The Parish Councils of Assington, Bures St Mary, Leavenheath, Little Cornard, Polstead & Stoke by Nayland

Written comments following Bramford-Twinstead (EN020002) Issue Specific Hearing 4 & Further combined response to Examining Authority's Submission Deadline 4

2. Relocation of the DVEast CSEC in Section D/E to Layham Quarry

DEDHAM VALE EAST SEALING END COMPOUND:
 PLAN VIEW
 SCALE 1:200

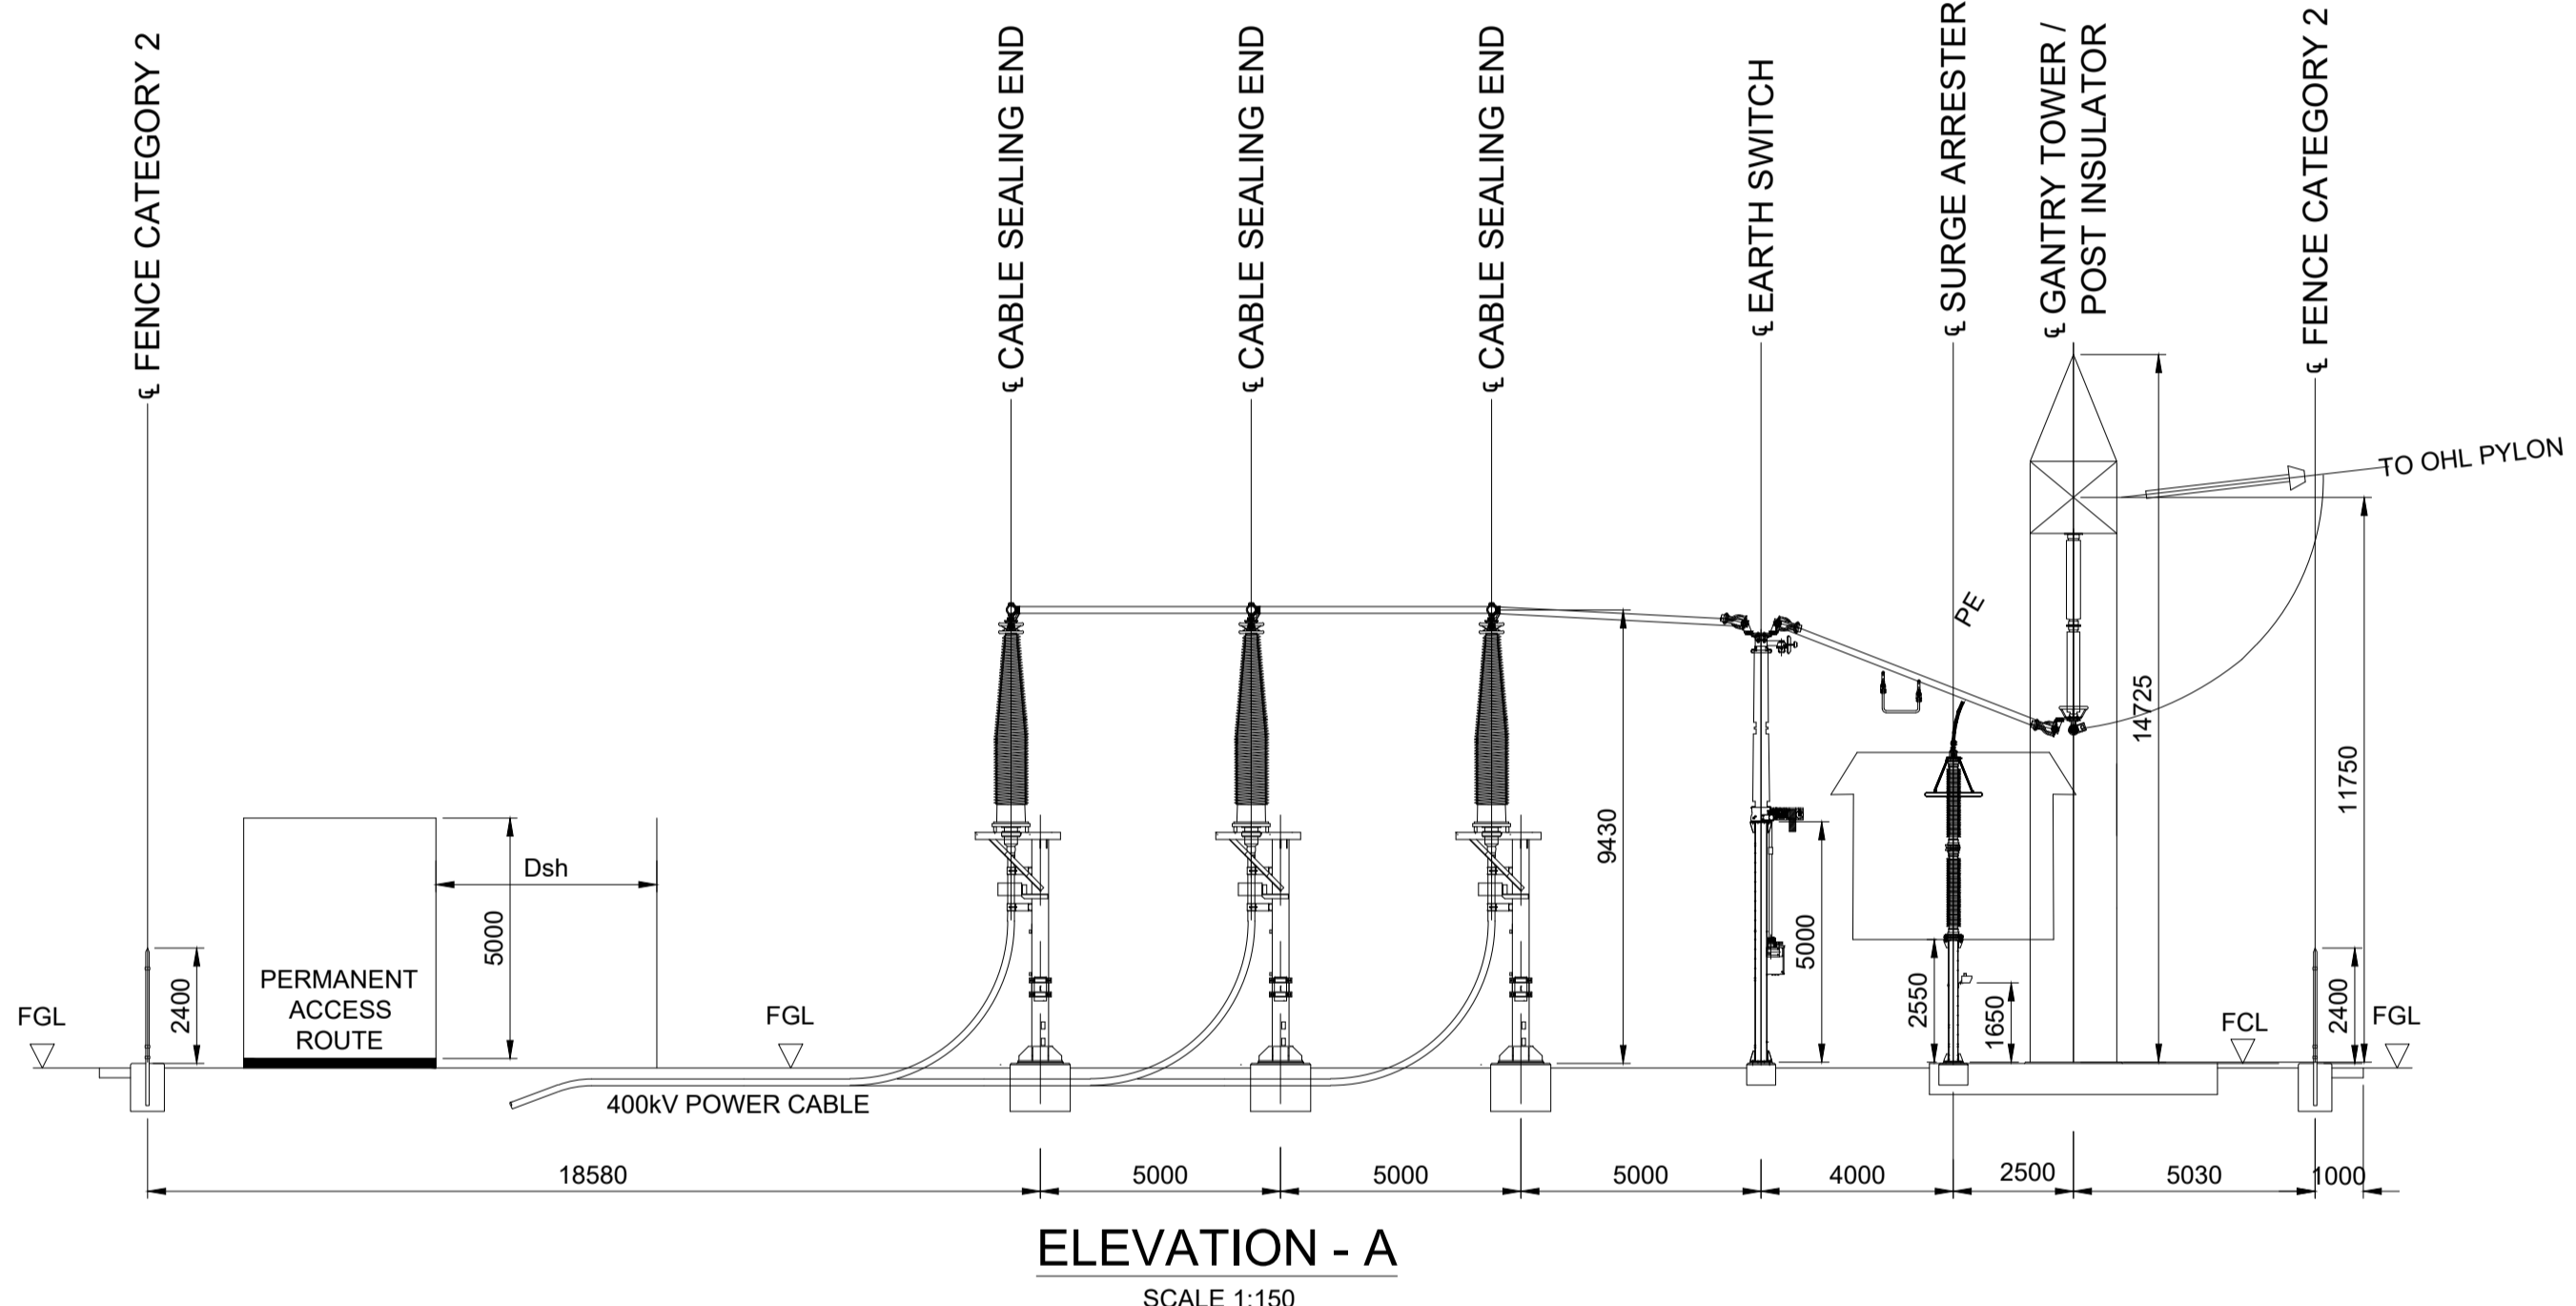
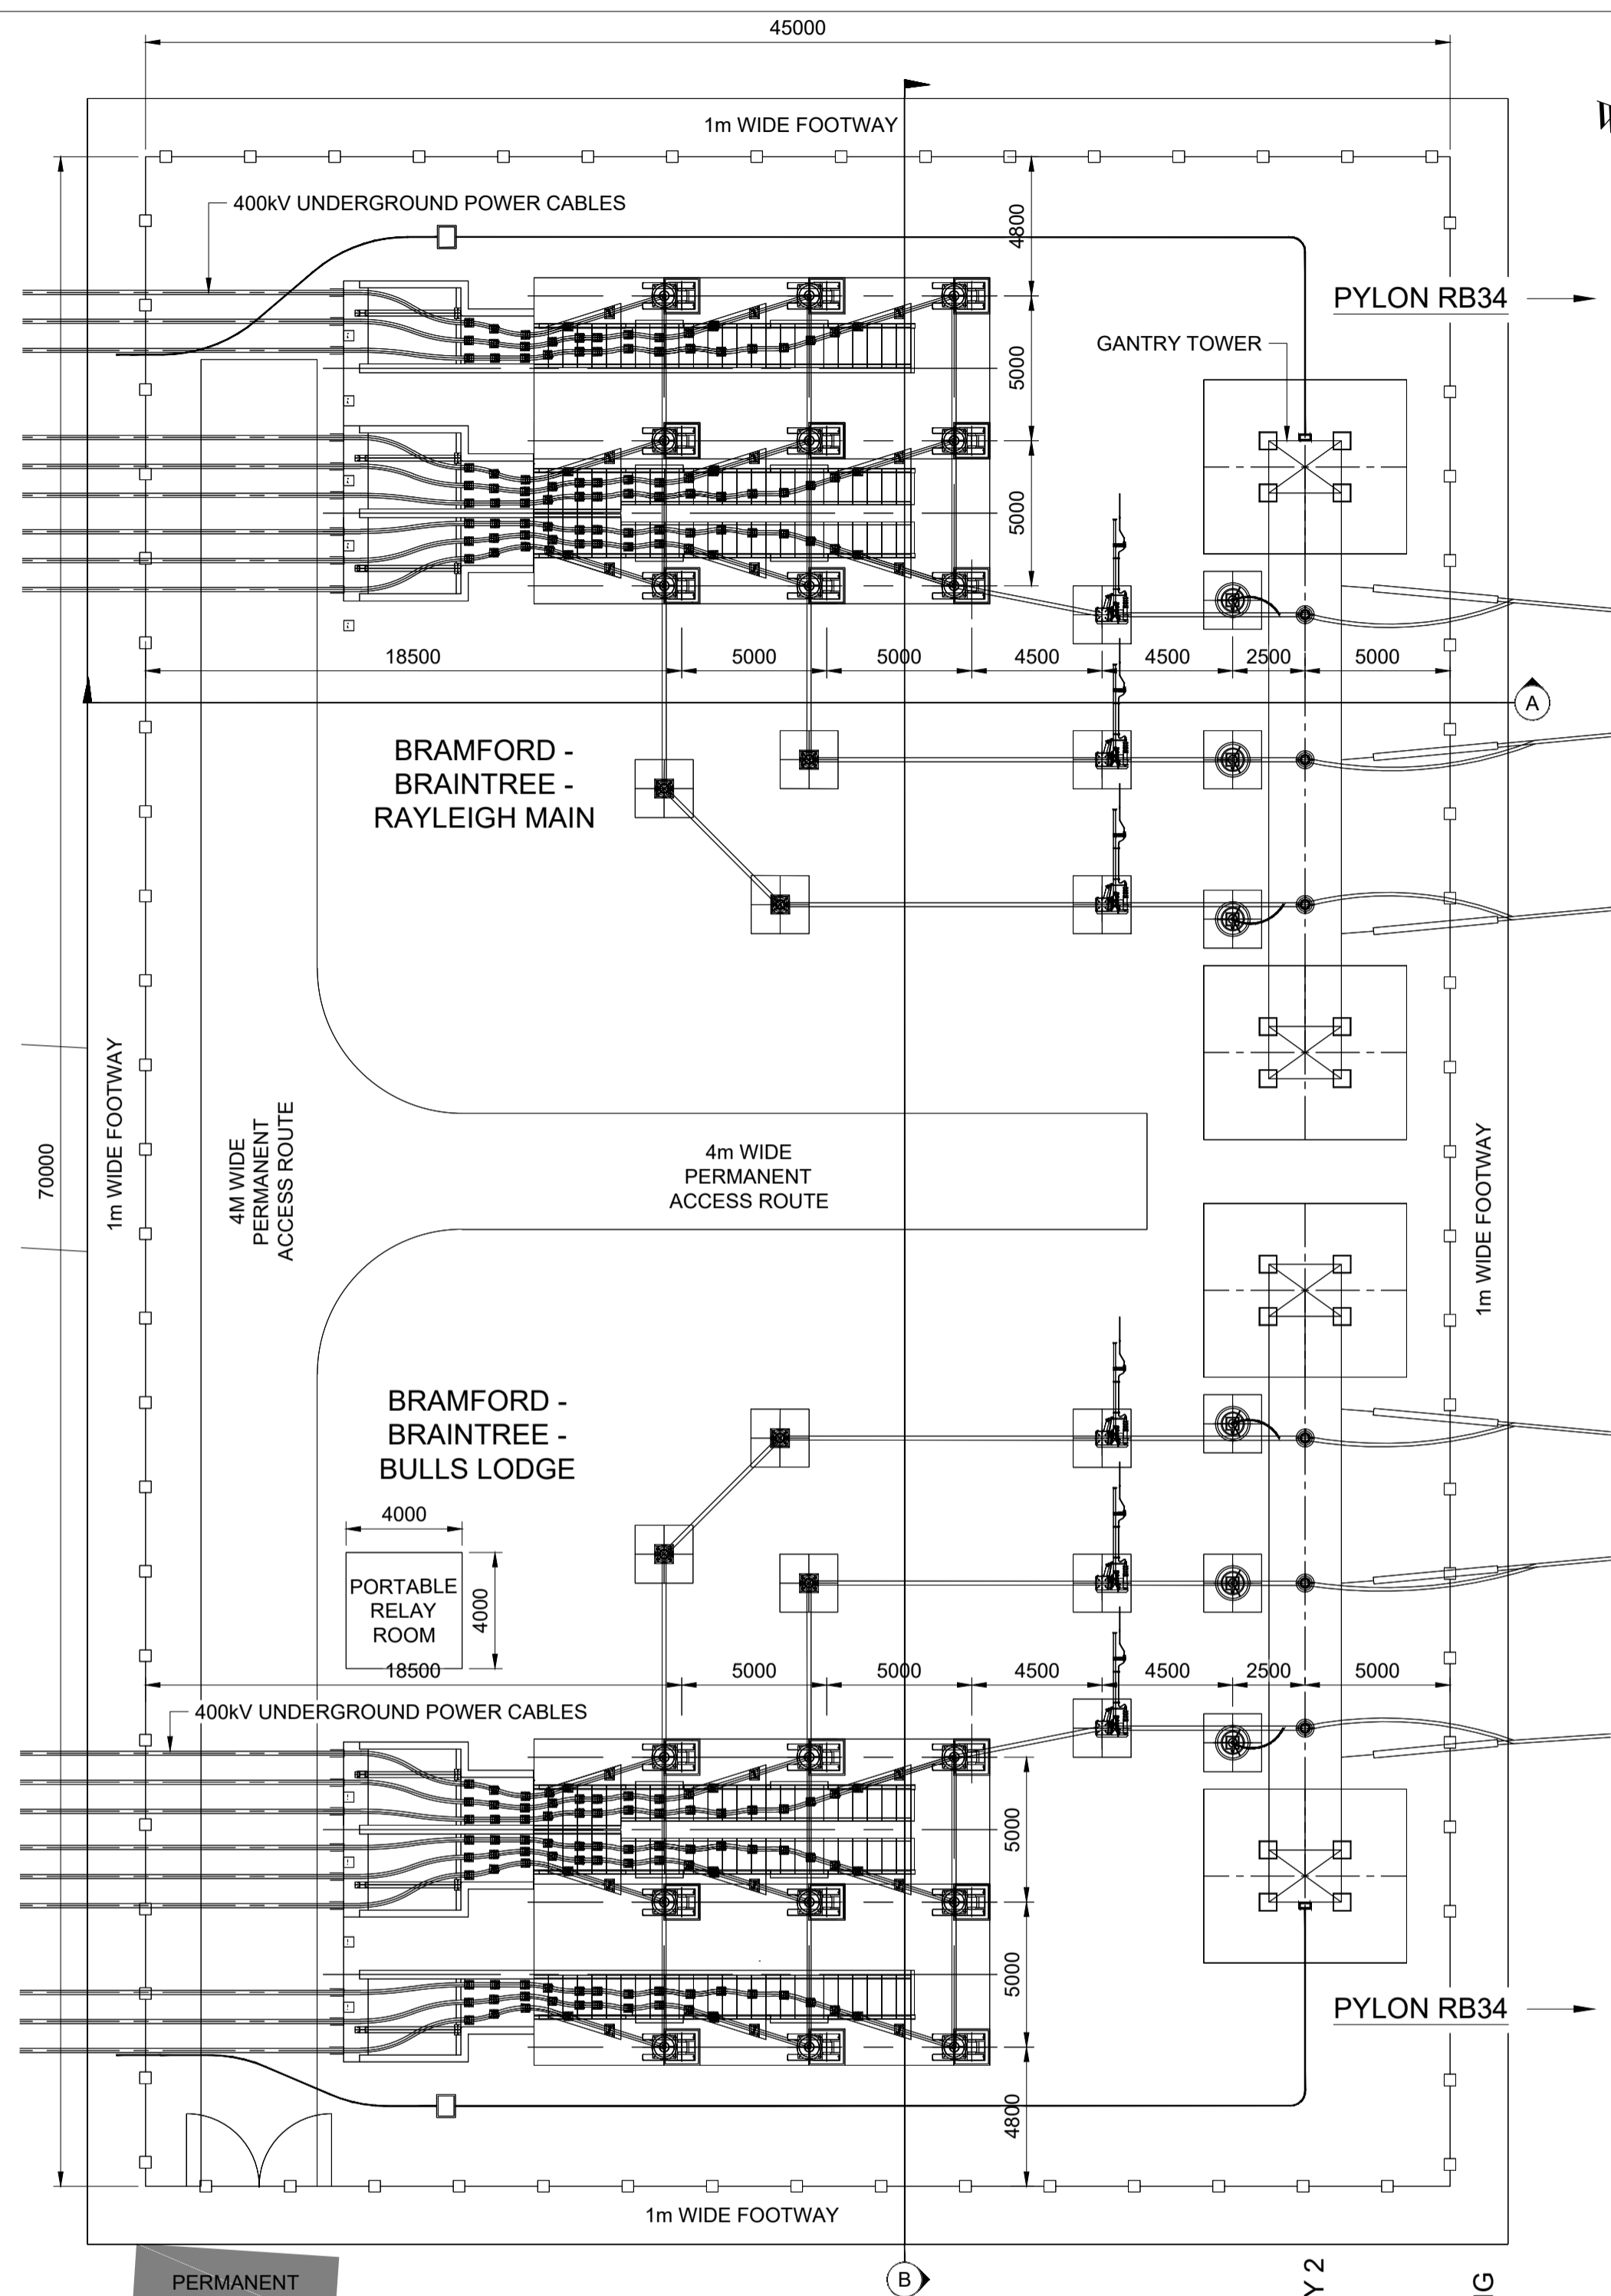
- 2.3 We wish to reinforce the industrial scale and nature of infrastructure required within a CSEC, essentially massive civil engineering structures comprising steelwork lattice gantries of near 15metres height distributed over a 50metre width (APP-023, Document 2.11.5). Such structures would be impossible to screen using embedded planting beneath the descending overhead power lines or above buried cables, and as such are destined to remain an essentially alien intrusion into the countryside for as long as the infrastructure is required.

- 2.14 **It is our proposition that the 70 x 45metre CSEC compound can readily be transposed to a site immediately adjacent to the western boundary of the quarry** and coincident with the line of Work No 2 and the site of new pylon RB32. This is a distance of just over 800metres from Millfield Woods site and results in the elimination of three new pylons. As far as we are aware, there are no civil engineering constraints that would impede construction or operation at this location, which appears to be in an already worked-out section of the quarry.
